A585 Windy Harbour to Skippool Improvement Scheme

TR010035

7.11 Environmental Statement Changes and Corrections Document

Version	Date	Status of Version
Rev 0	May 2019	Deadline 2 Submission
Rev 1	July 2019	Deadline 4 Submission

Rev	Status	Rev. Date	Purpose of revision	Drawn	Check'd	Appr'd
1	SS	MAY19	S8 - DEADLINE 2 SUBMISSION	JN	KB	NH
0	SS	OCT18	S8 - DCO SUBMISSION	JN	KB	NH

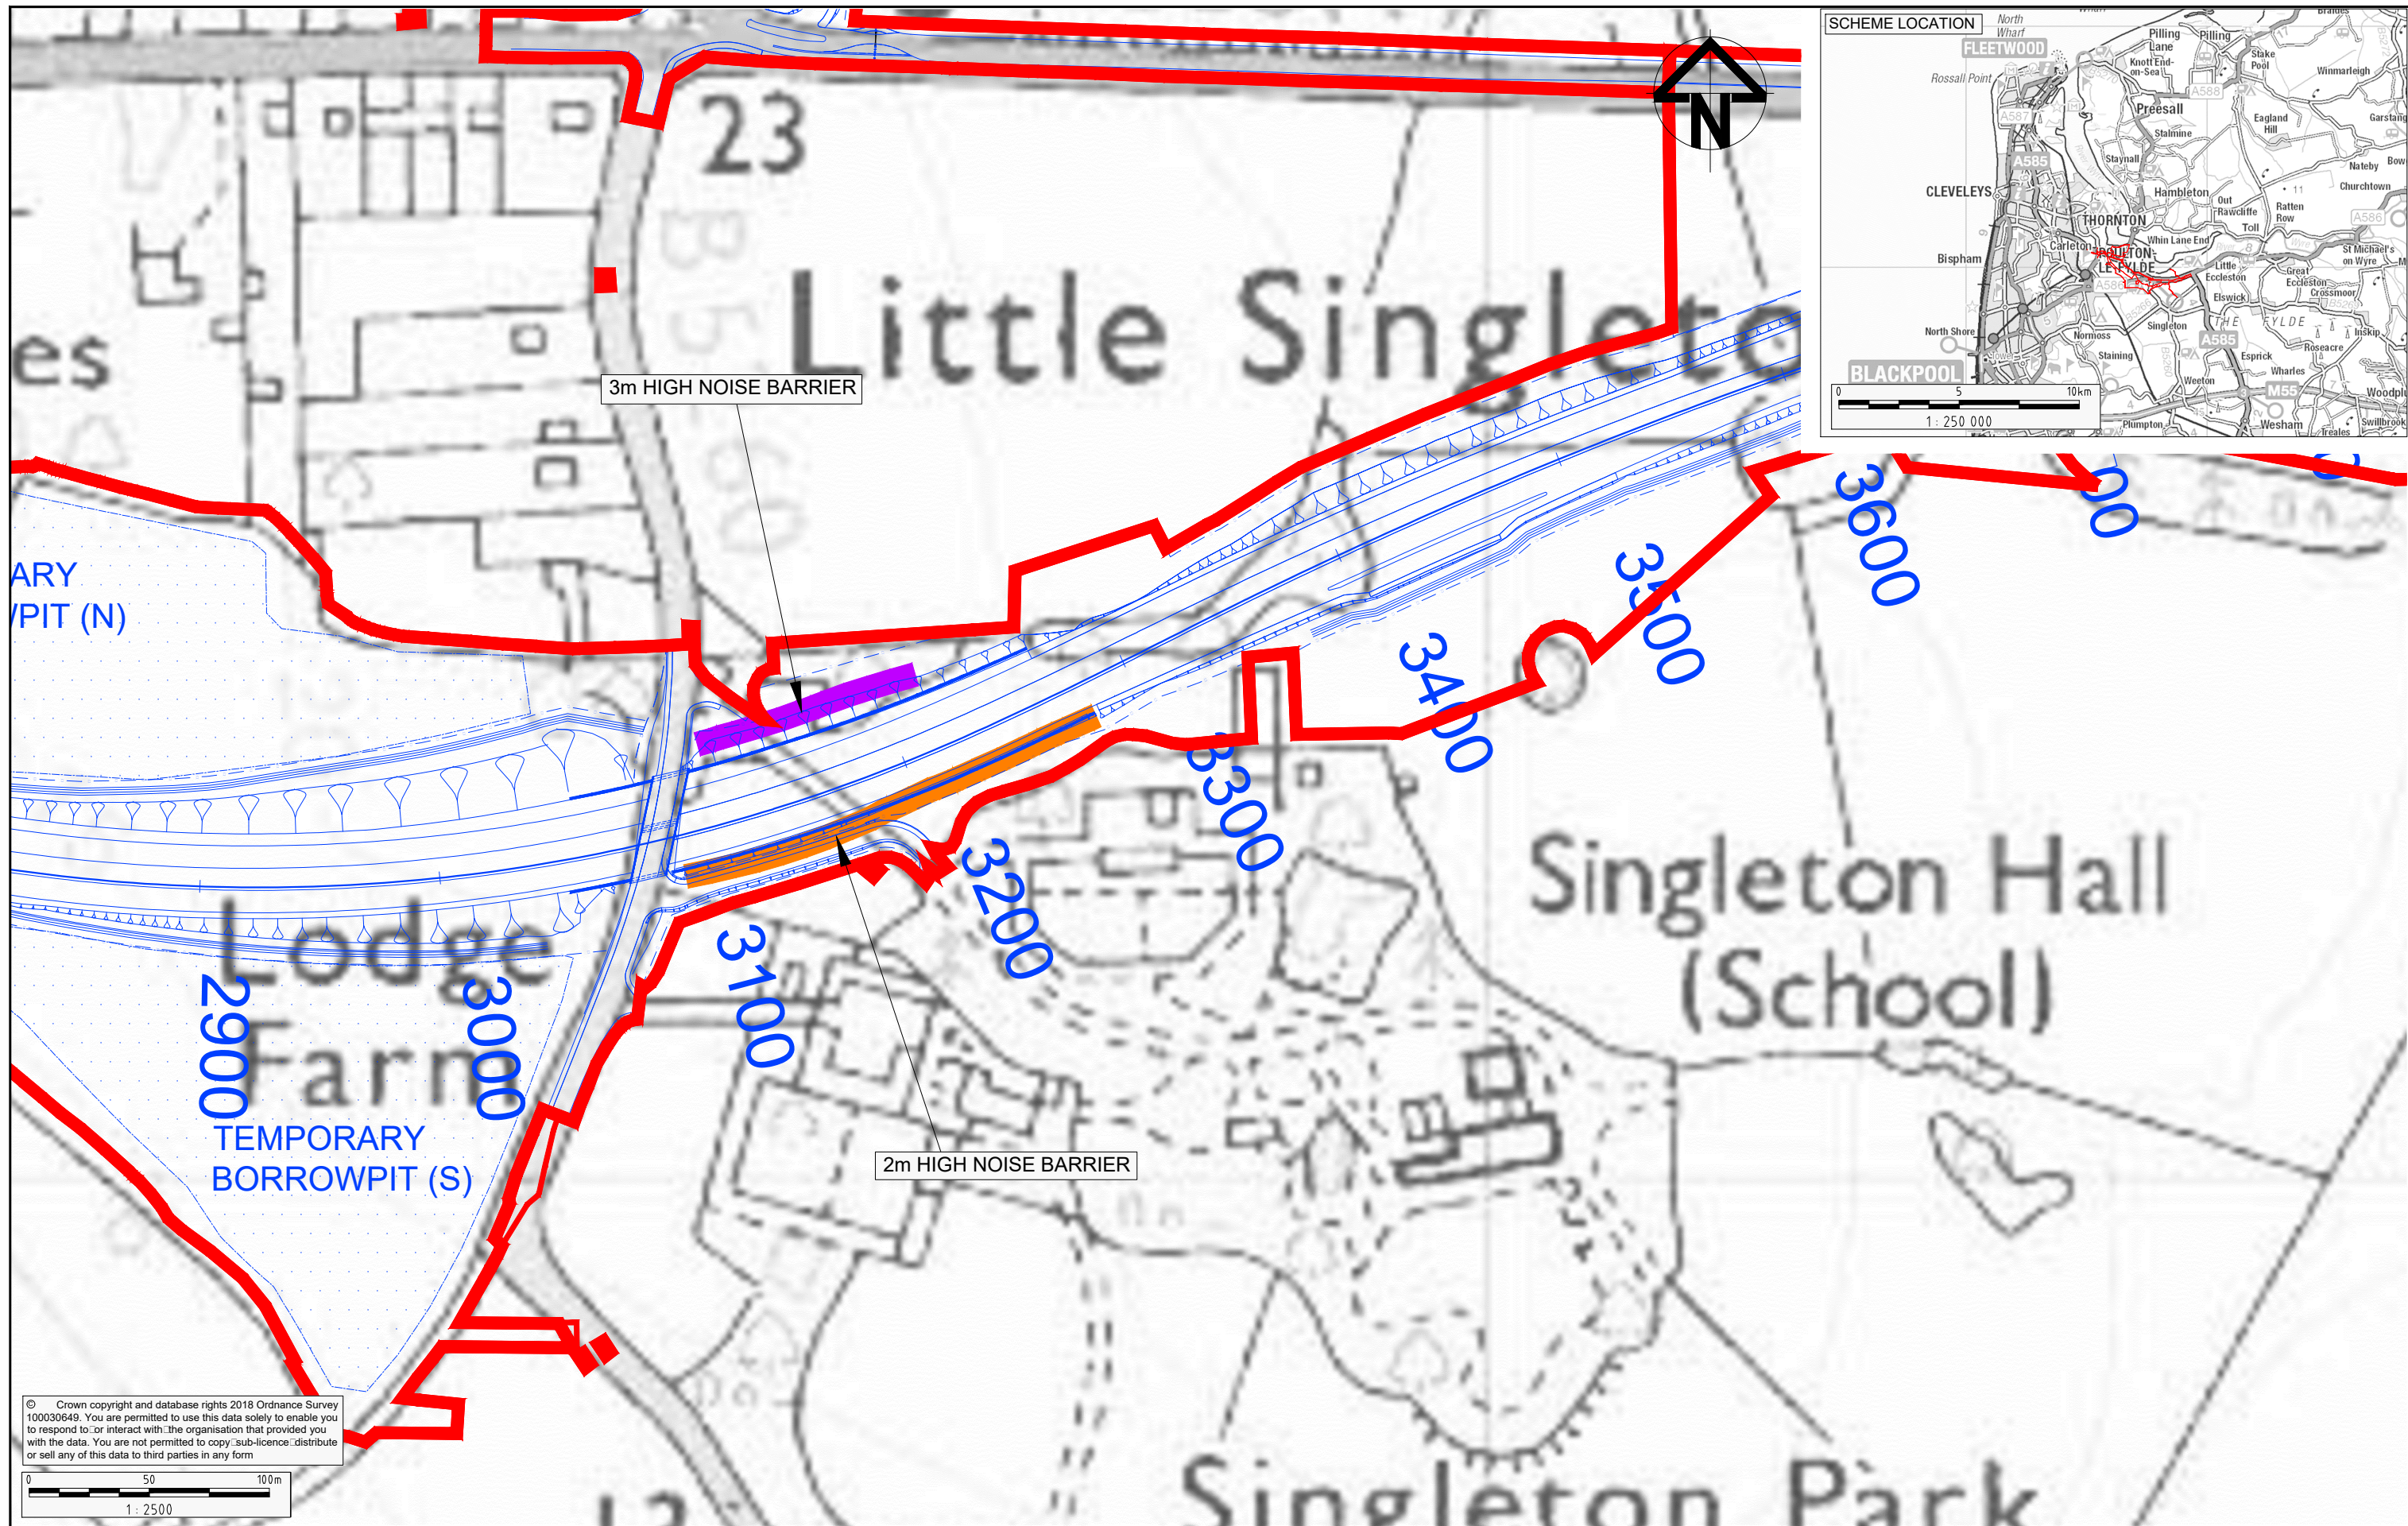
Document Reference Number	Document Name	Amendment Required	Reason
			TR010035/APP/7.10).
6.11	ES Chapter 11: Noise and Vibration	Update to Figure 11.4: Noise and Vibration – Noise Mitigation within the Study Area presented at Appendix D to show heights and locations of earth mounds and acoustic fencing at a larger scale.	Requested by the Inspector within the first round of written questions (document reference TR010035/APP/7.10).

APPENDIX F – Updated Figure 12.2: Road Drainage and The Water Environment - Aquifers

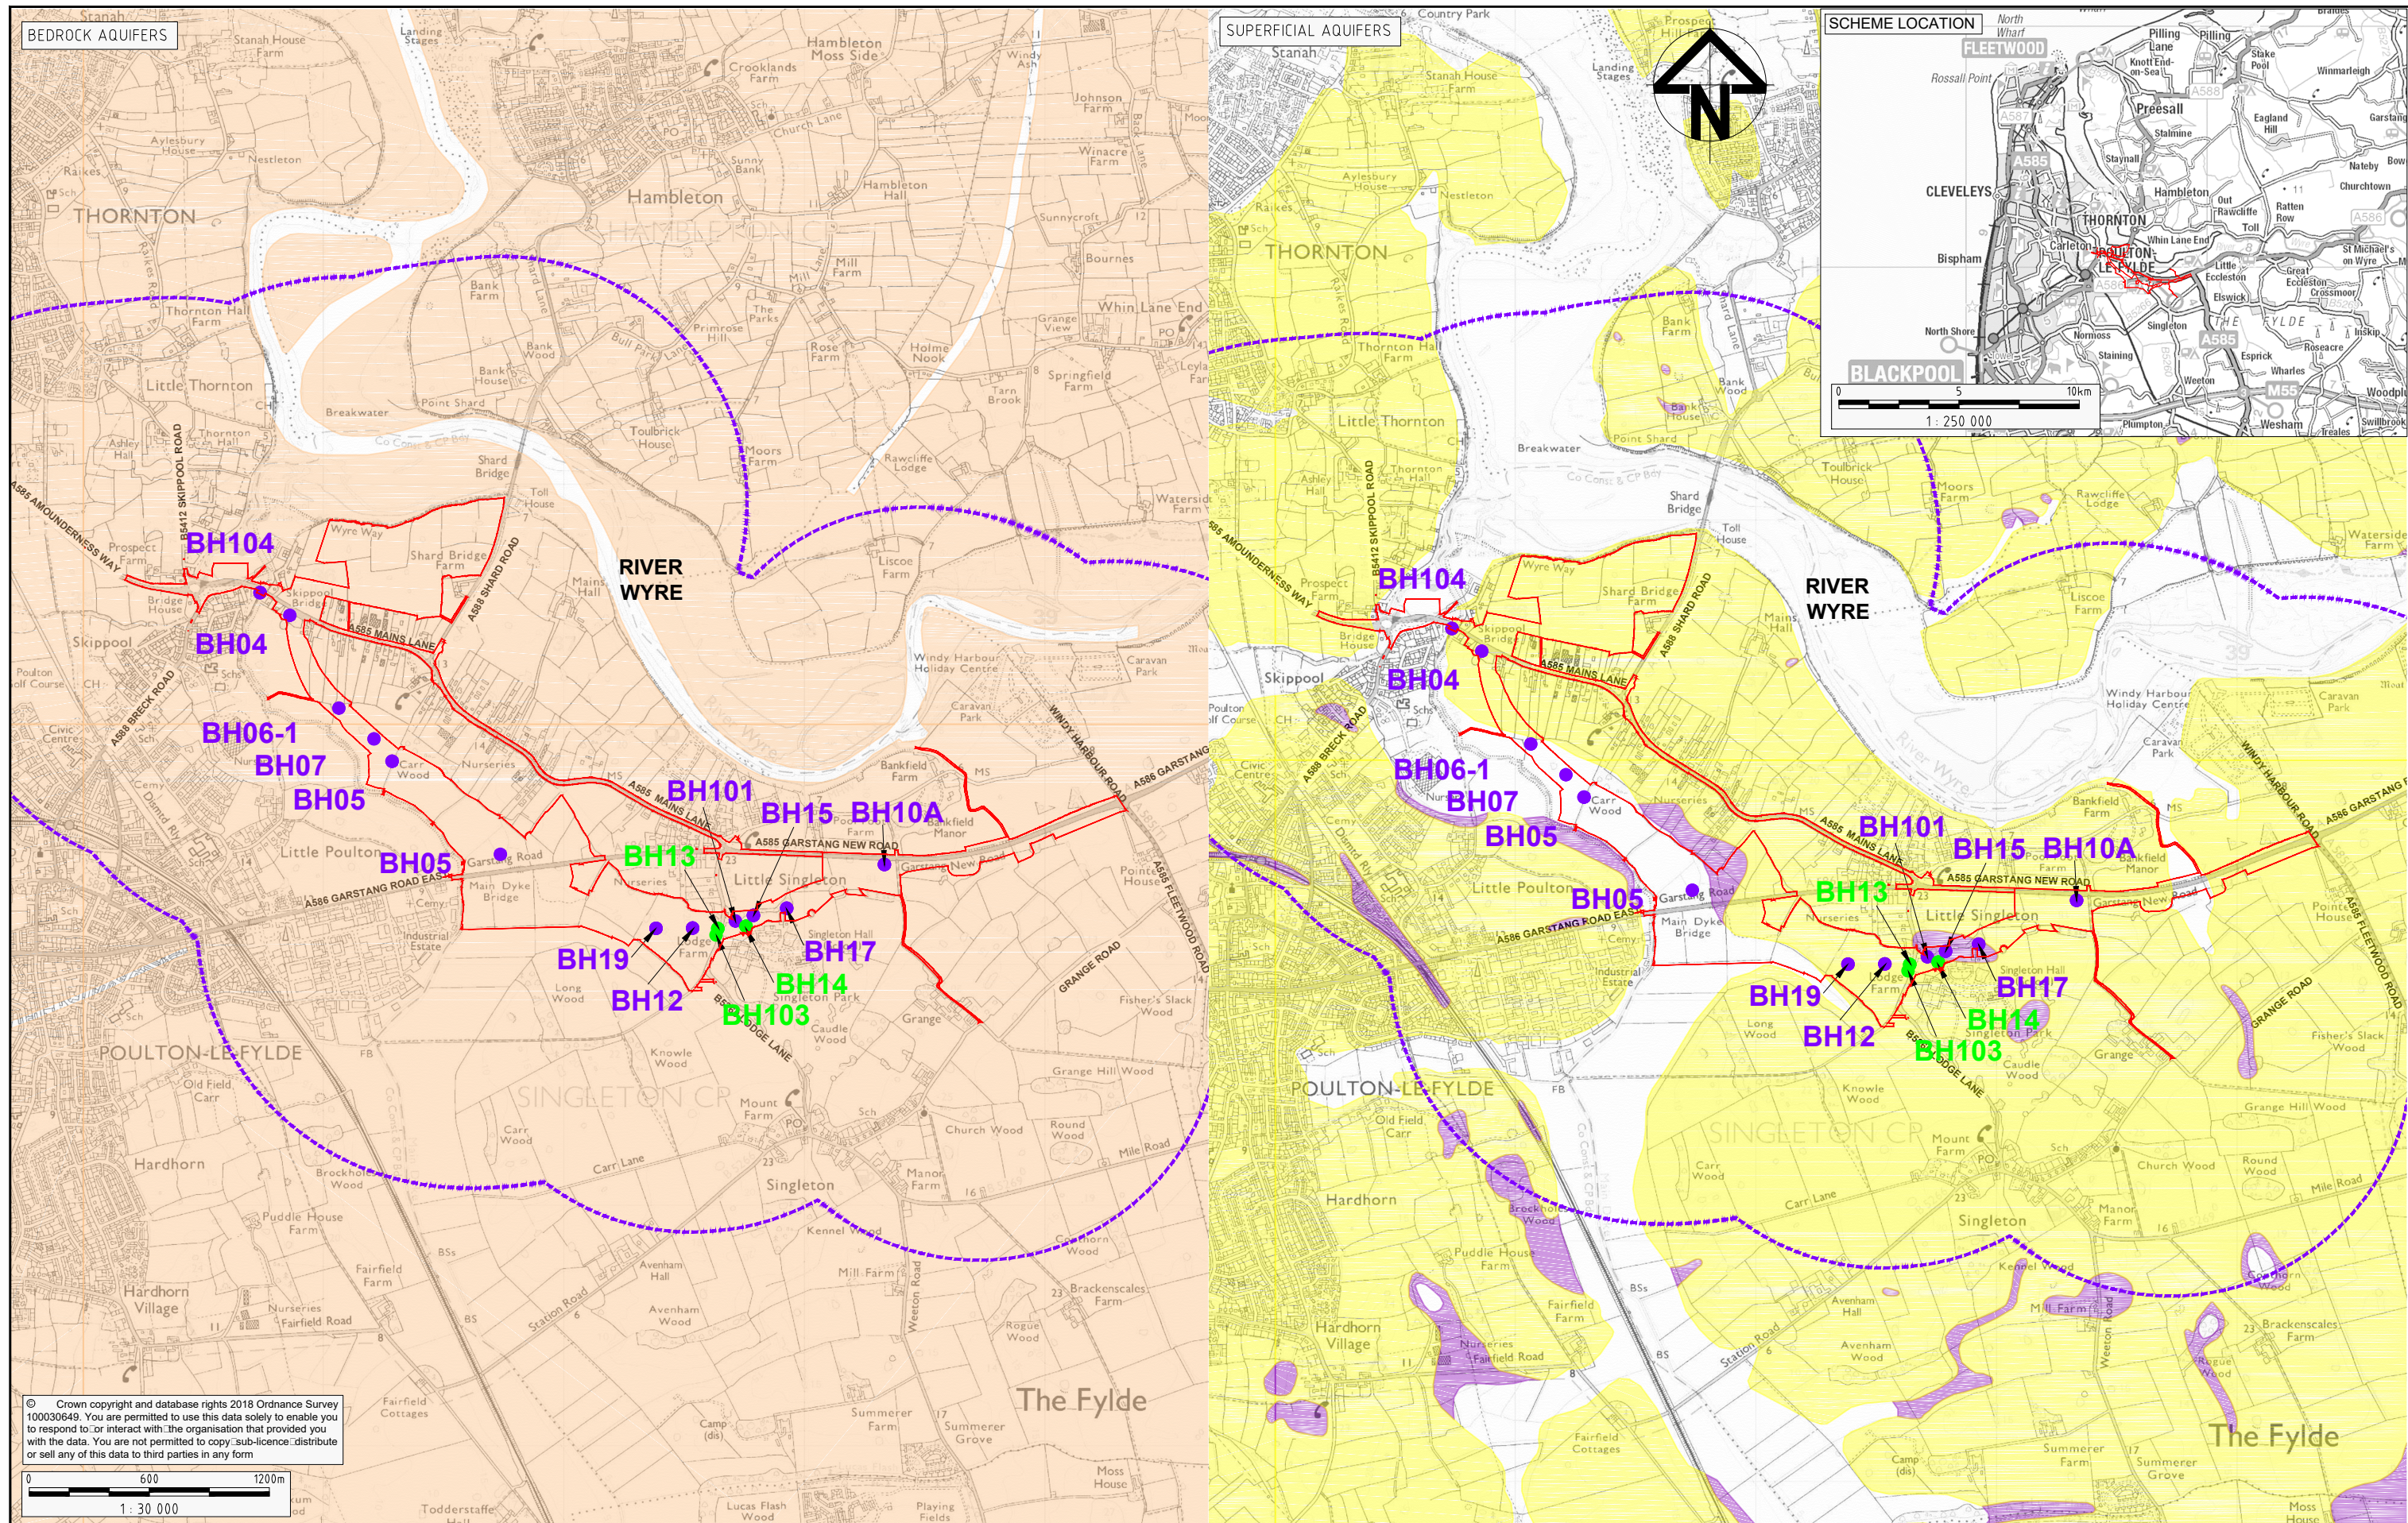
Appendix E – Updated Table 4-1 within Appendix 11.3 (document reference TR010035/APP/6.11.3).....	34
Appendix F – Updated Figure 12.2: Road Drainage and The Water Environment - Aquifers	36

Insert 12-3: Road Drainage and the Water Environment - Maximum flood Extents in Baseline and with Scheme (option model) Scenarios (0.5% AEP tidal event)

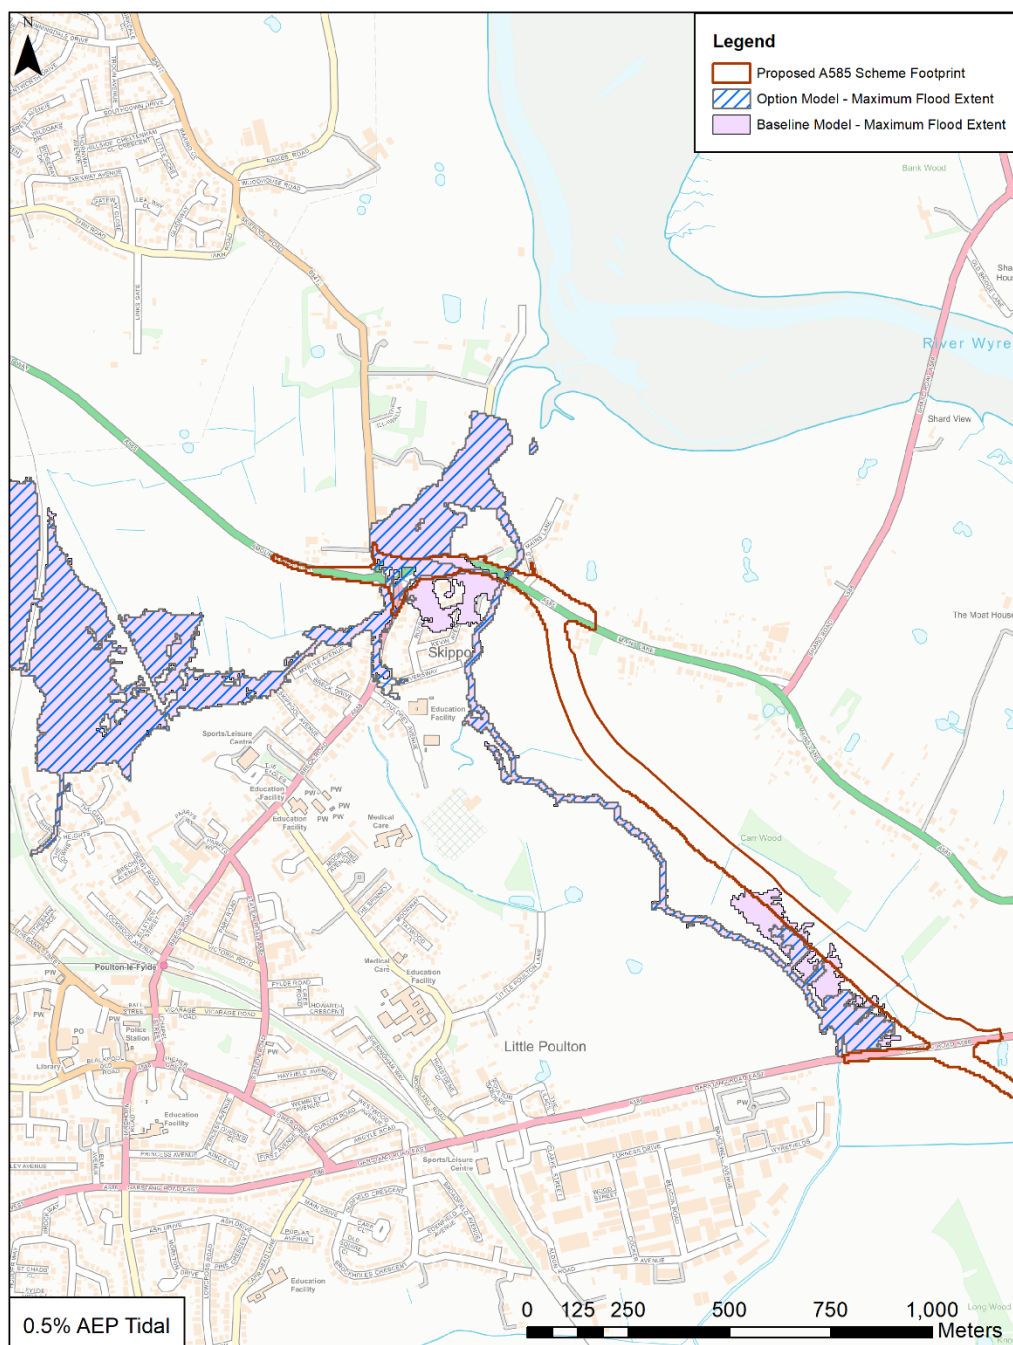
6.12	ES Chapter 12: Road Drainage and the Water Environment	Replacement Insert 12-3: Road Drainage and the Water Environment - Maximum Flood Extents in Baseline and with Scheme (option model) Scenarios (0.5% AEP tidal event).	As a result of the updates made to the Flood Risk Assessment (document reference TR010035/APP/5.2 – Rev 1).
